CROSSROADS MIXED USE FILING NO. 2

CONSTRUCTION PLANS

NOVEMBER 2022

STREET IMPROVEMENT PLANS

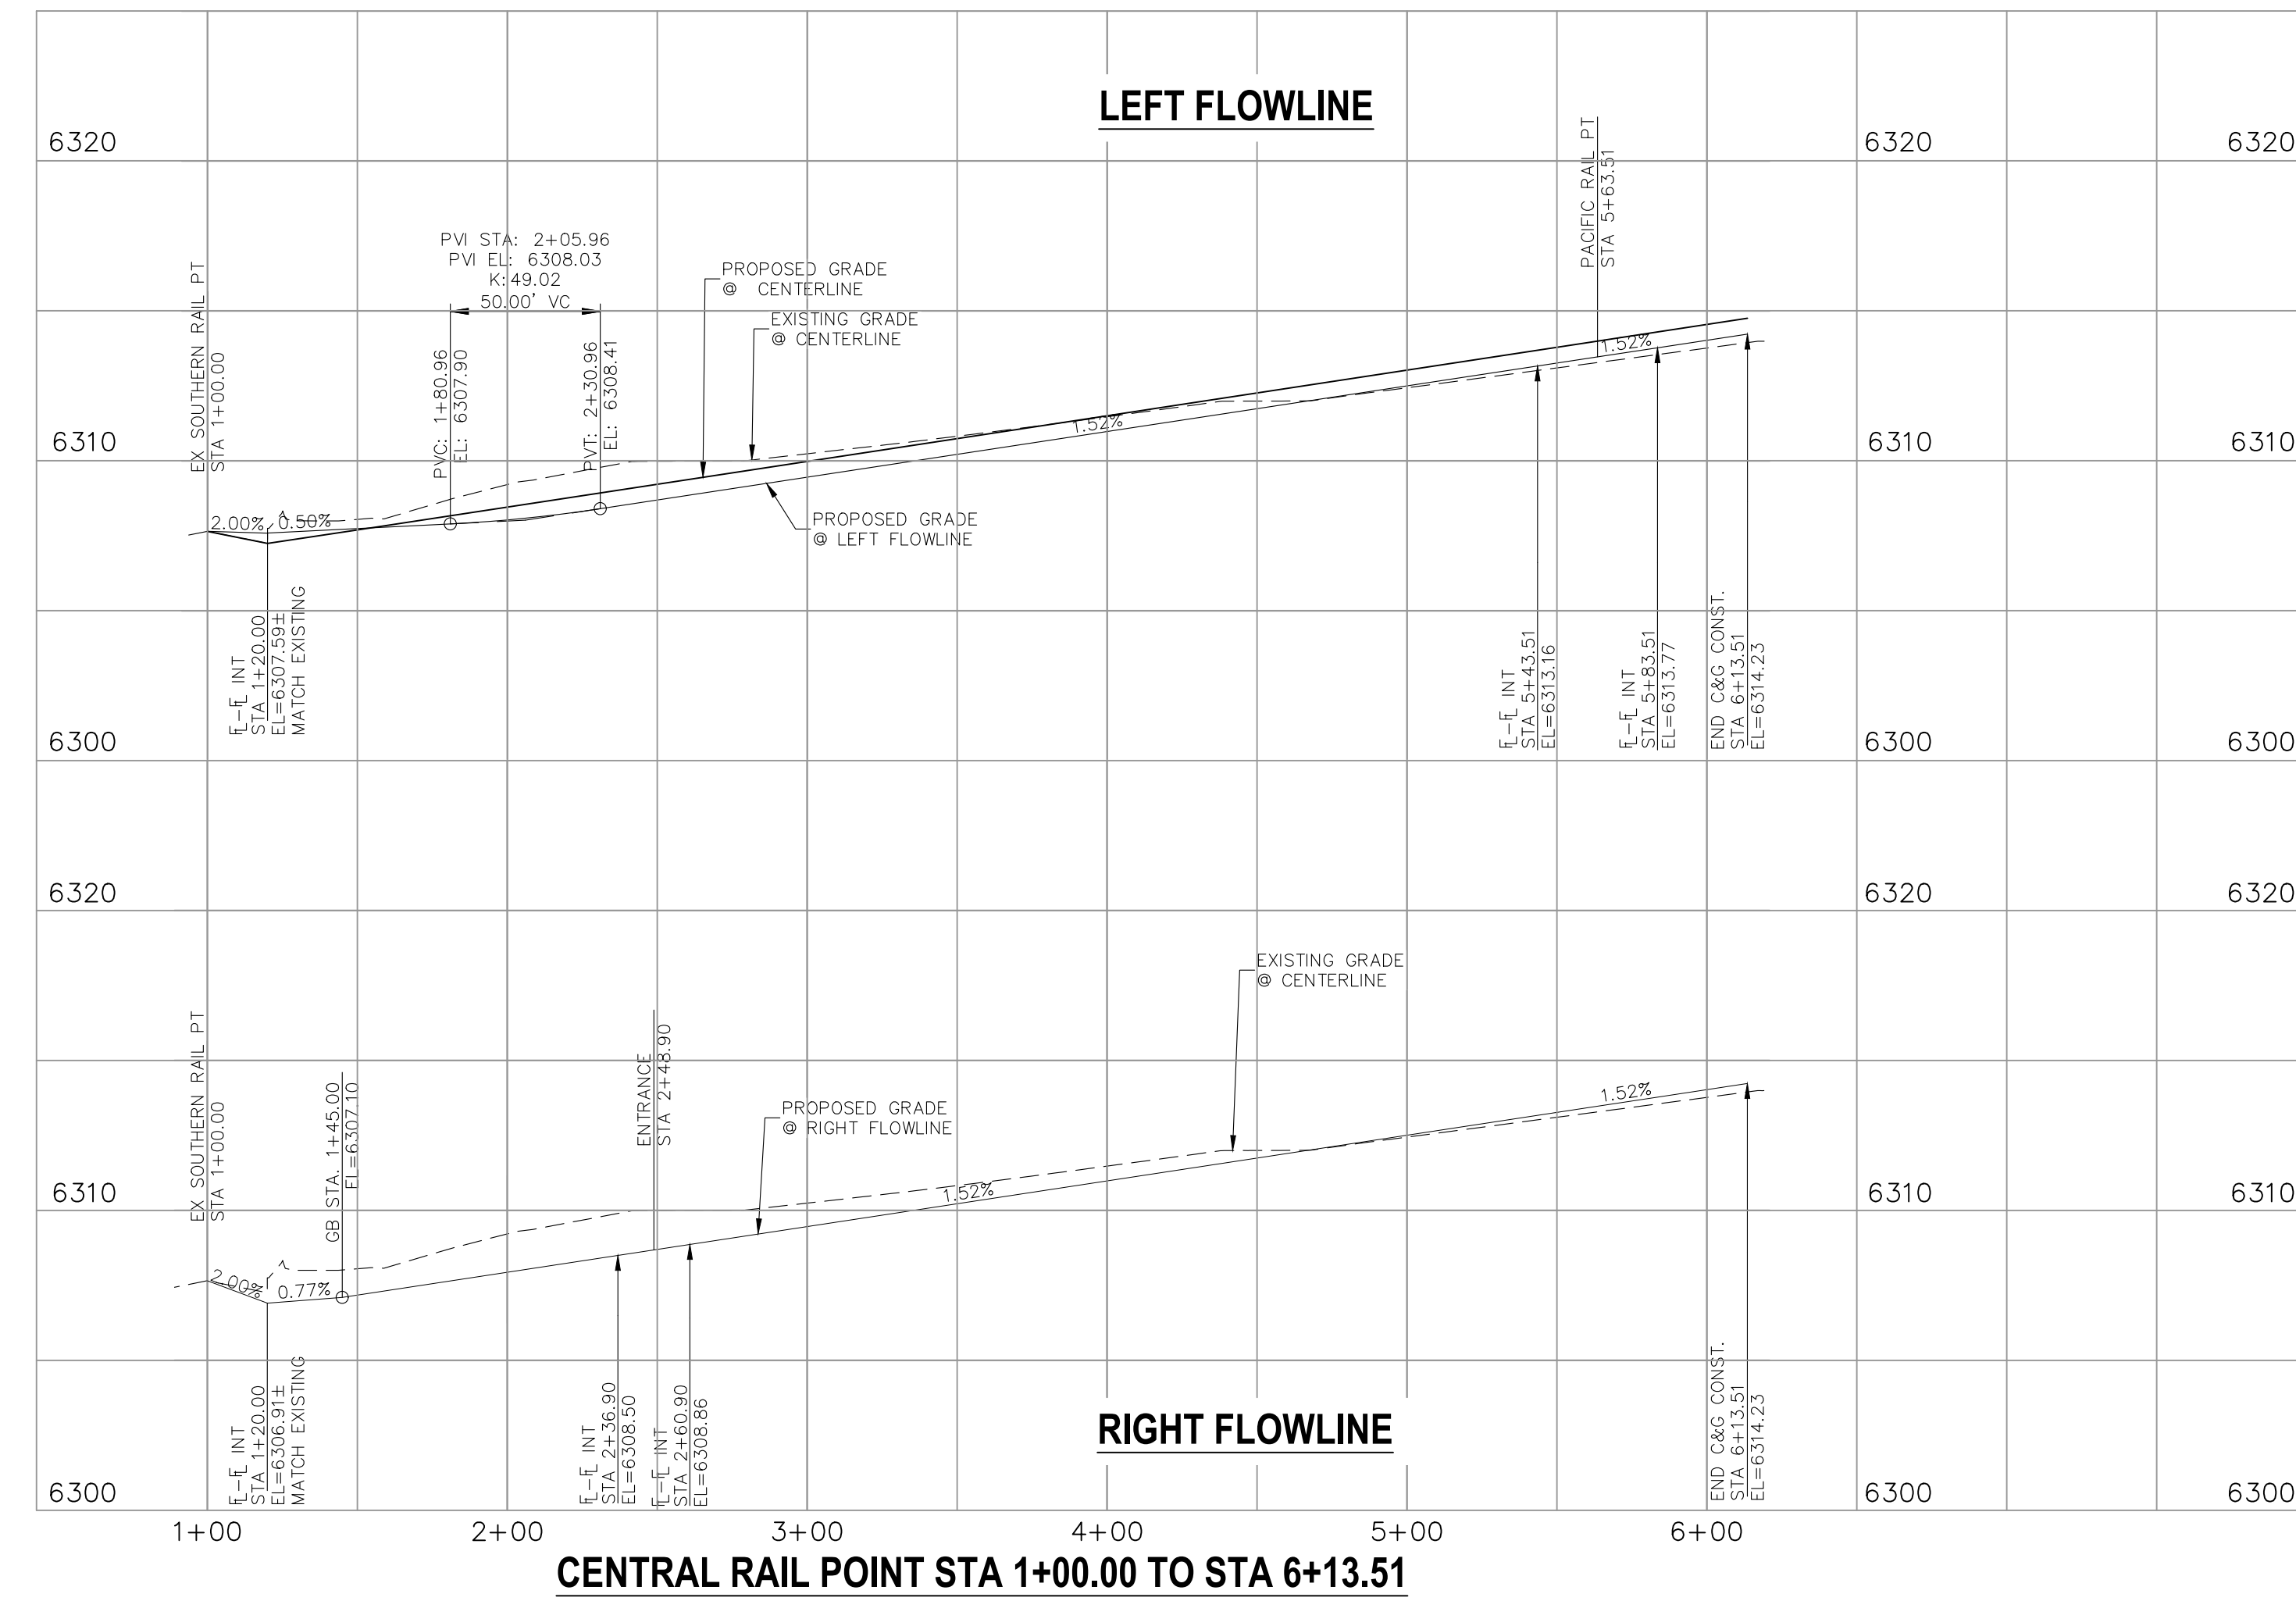
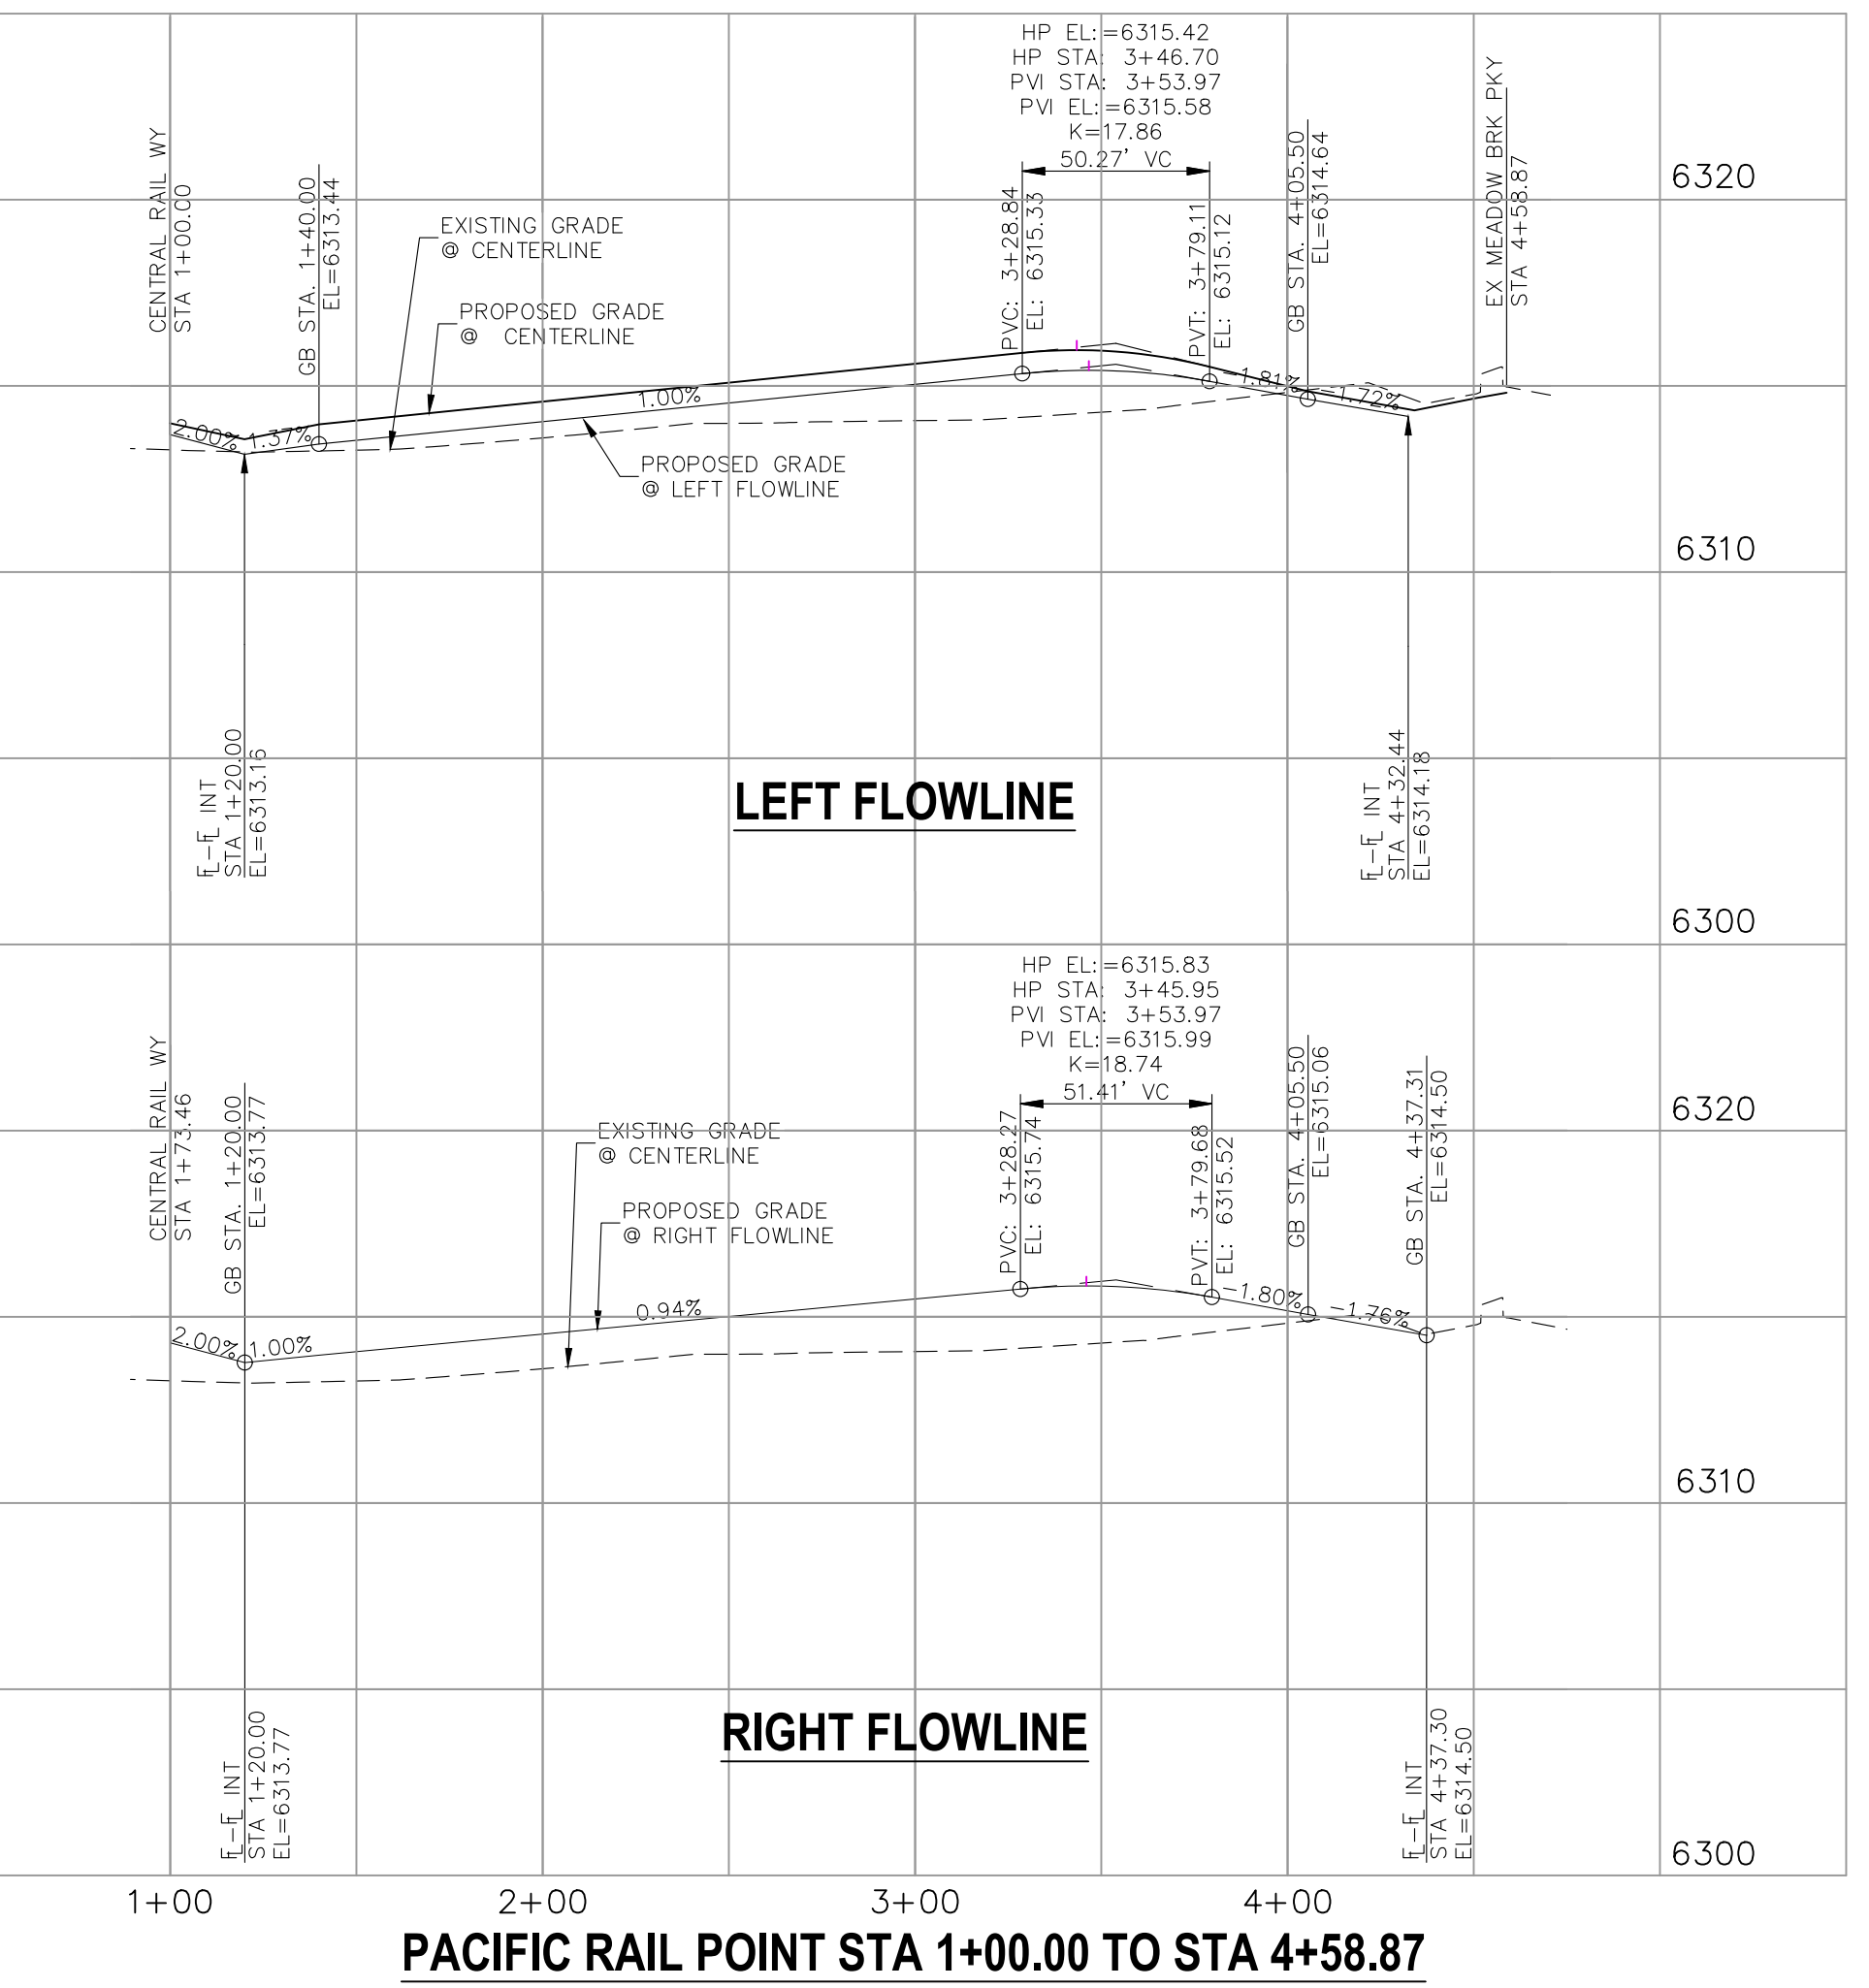
This is shown as private on drainage report. Revise to label all storm as private.

Provide centerline line bearing and distance and curve data.

Revise to provide a sidewalk/crosswalk across proposed curb ramp per ECM 2.5.2.C.3 and 2.5.2.C.4.

There are several inconsistencies between these drawings and the drainage map proposed conditions. These include: labeling of private and public storm sewer, mismatched pipe sizes, and missing proposed swales. Coordinate with drainage engineer to remove inconsistencies between the two documents.

Provide centerline line bearing and distance and curve data.

Add property lines to the legend and show on plans.
